**Consultation Response from Mike Hibbert,
KC Waste Strategy(Refuse & Recycling)**

2023/91408 Land adj, 21, Thomas Street, Lindley, Huddersfield, HD3 3JJ

Erection of care home (Class C2) with sub-station, associated car parking, access, servicing, landscaping and other associated works

Responding Ref: WPS 23-031

Drawing Title  
Proposed Site Plan

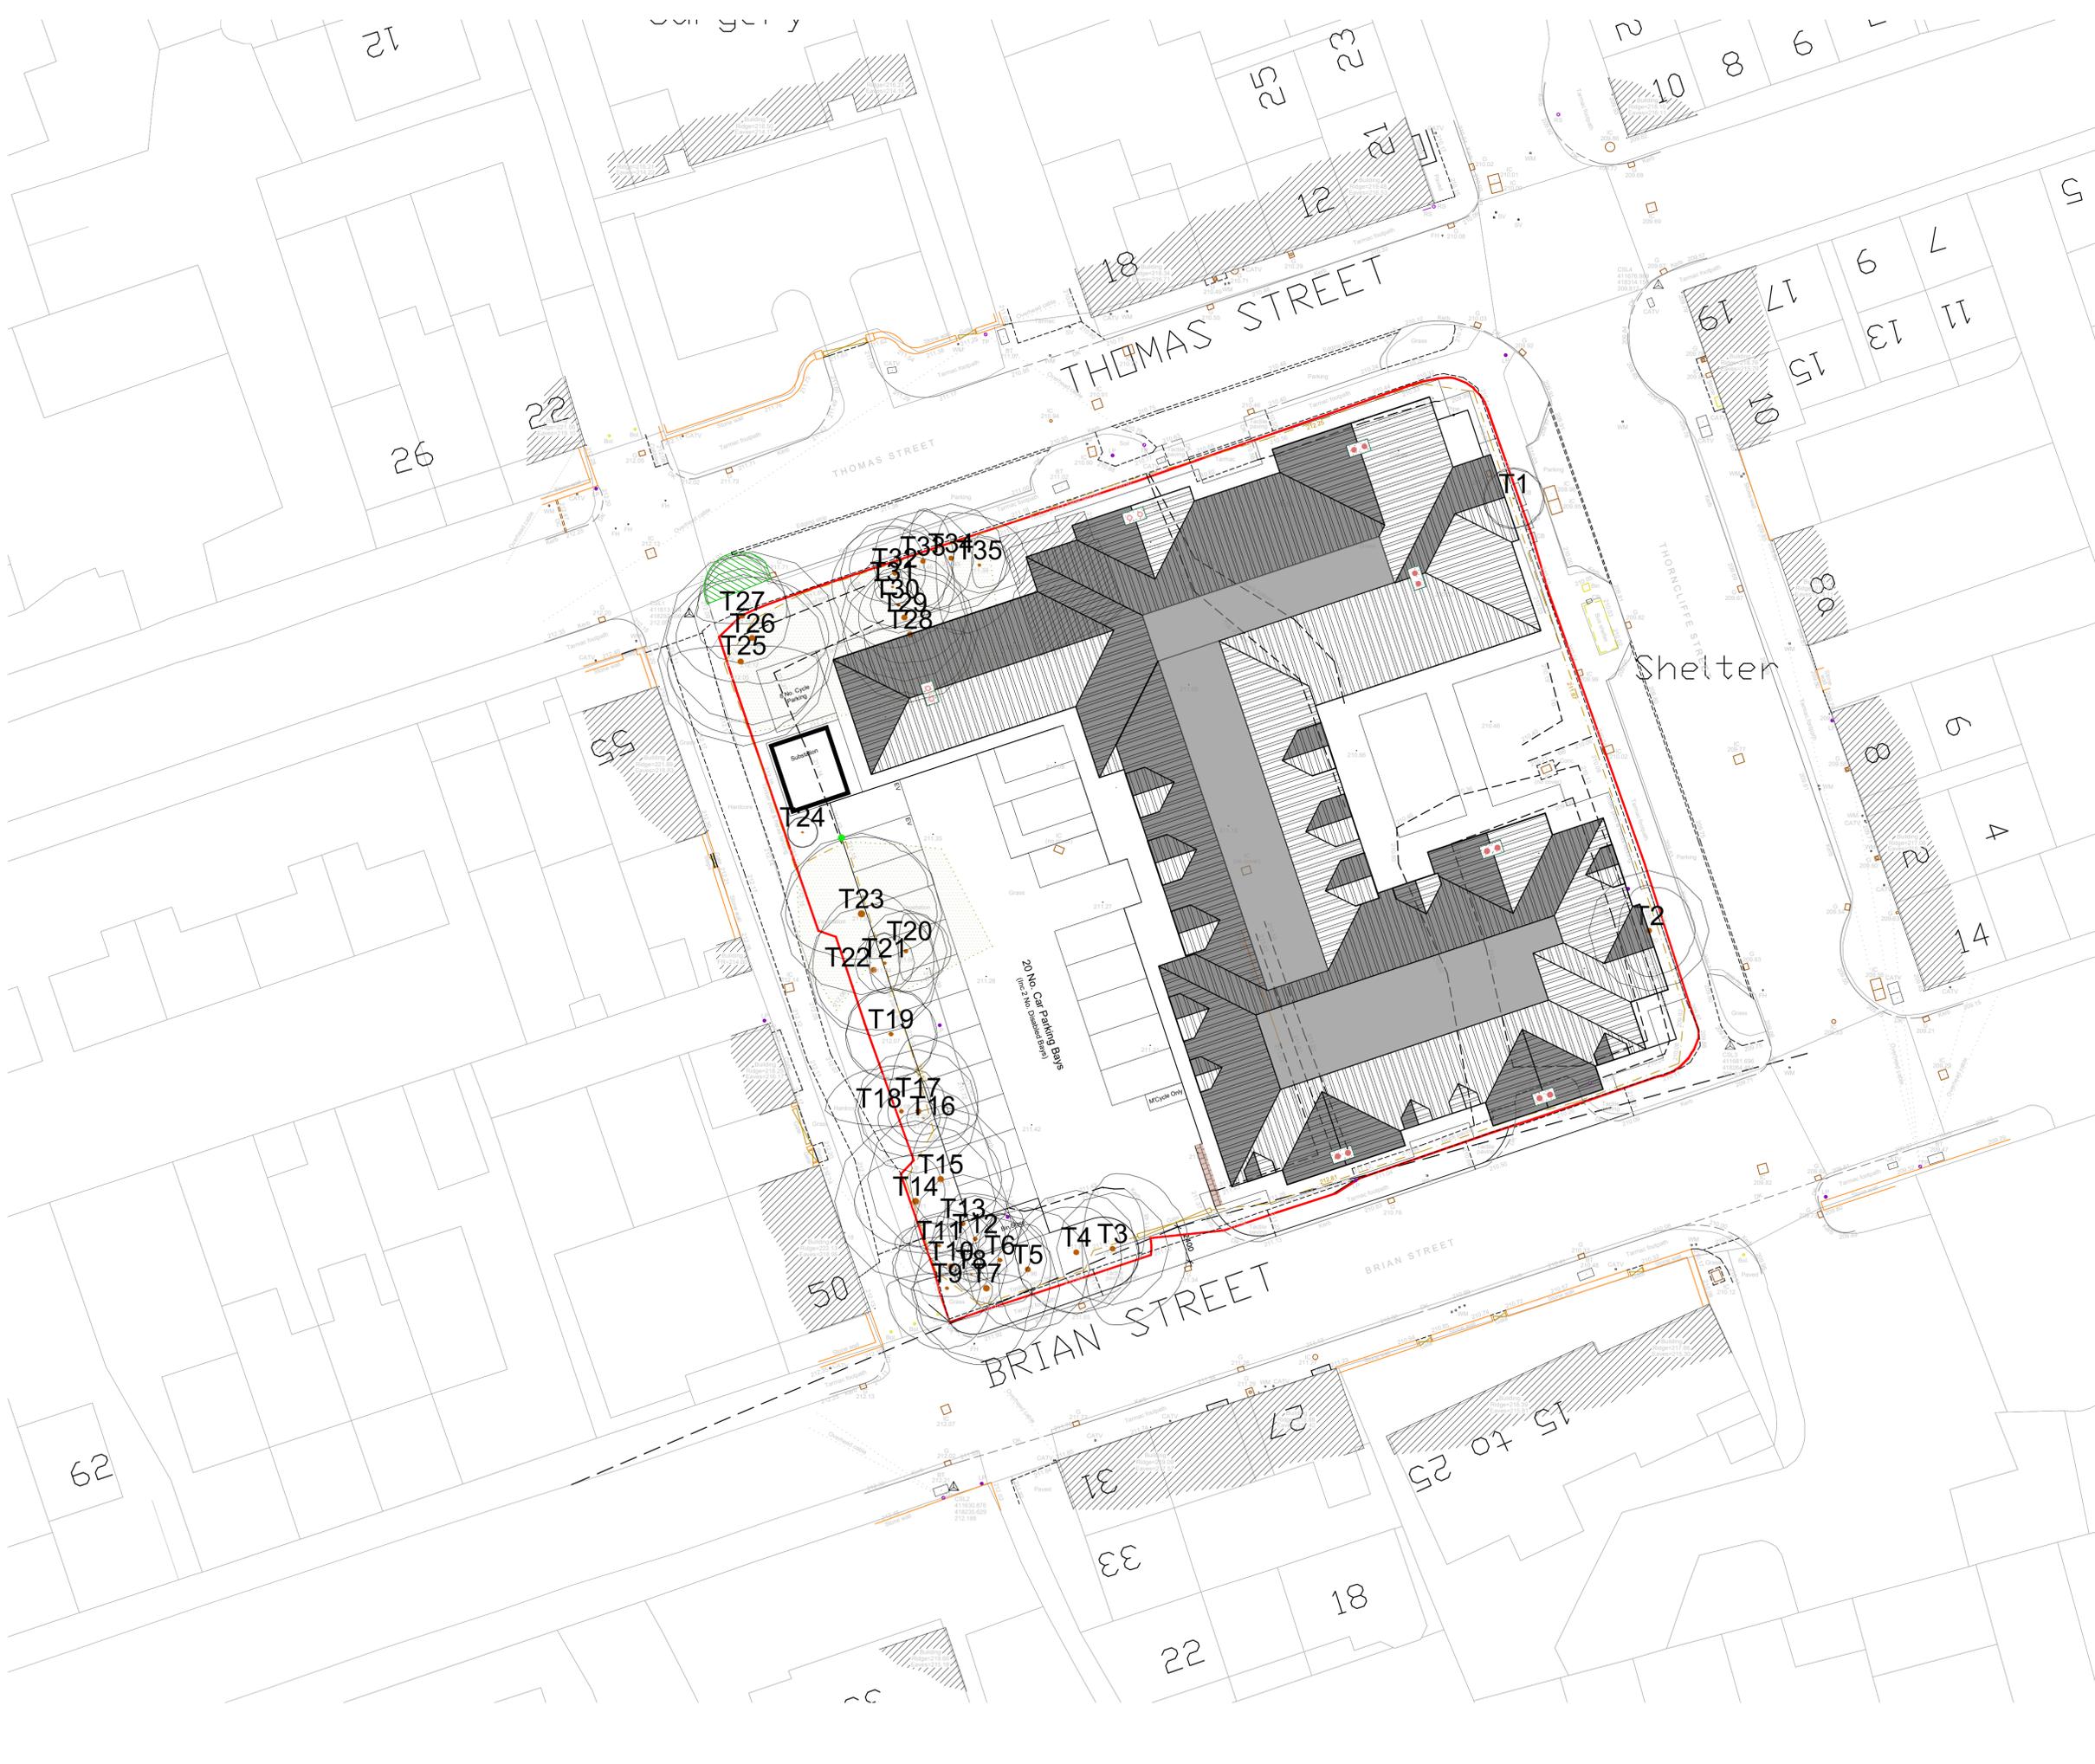
The Proposed Site Plan (9-2 Rev Q) dated 5/5/23 shows the location of a bin store near site entrance in the southwest corner of the site, which is accessible via Brian Street.

- The amended location of the bin store and access arrangements are welcomed.
- For a 60-apartment development the required waste storage capacity, discounting any waste generated from the communal areas and kitchen, should be approximately 4200ltrs (70ltrs x 60) for both residual and recycling containers. The bin store identified on the plan therefore must be sufficient to accommodate 8 X1100ltrs wheeliebins. Some provision should be made for waste generated from the communal meeting area, office space and kitchen. Separate wheeliebins will be required for residual

- No details are provided in the application relating to storage of clinical waste, sharps containers or offensive waste streams arising from the premises. Wastes of this nature should be managed in accordance with Health Technical Memorandum (HTM) 07-01 on best practice for waste management and ways to improve the environment and carbon impacts of managing waste. There must be appropriate secure storage within the building for sacks, containers or wheeliebins and the applicant should have regard to access requirements of contractor's vehicles collecting these wastes from the site. Any additional details on the size and design of the waste storage and confirmation of how clinical wastes are managed would be welcomed.

- Guidance indicated the floor space for 1100ltr wheeliebins is 1575mmx1190mm with space to manoeuvre the bins within the store, so the bin store dimensions should reflect the number of bins and will depend on configuration within the store.

- The bins should be contained within a purpose designed store. Details of bin store construction requirements including screening can be found in the Kirklees Waste Management Design Guide 2020. The bin store should be secure to prevent theft, unauthorised use/ fly tipping, arson or rough sleeping. If the store has gates these must be wide enough to enable passage through with a wheeliebin.

- Bin store surfaces should be durable and waterproof enough to withstand heavy duty cleaning such as power washing. The storage area needs to have suitable drainage.

- The drag out distance for wheeliebins from a Bin store/ premises to the collection vehicle is under 15m that is acceptable.
- The bin storage area and access routes to the Bin Collection Point (BCP) should be constructed to withstand point loading and movement, impacts of larger bins over time, and to resist future rutting, pitting, cracking, or other such surface degradation that would impair bin manoeuvring. There should not be a step between the floor level of the store and car park level. Active measures should be taken to avoid cars parking in front of the doors to the waste store.

- Suitable site access and manoeuvrability space for a Refuse Collection Vehicle is vital to the Council's ability to discharge its obligation to collect waste from properties. This obligation will exist in perpetuity on any development and as such will be a critical consideration in the layout of the site. It is welcomed that the proposal is to transfer from the bin store to an RCV on Brian Street rather than an RCV having to enter the site and turn within the car park.
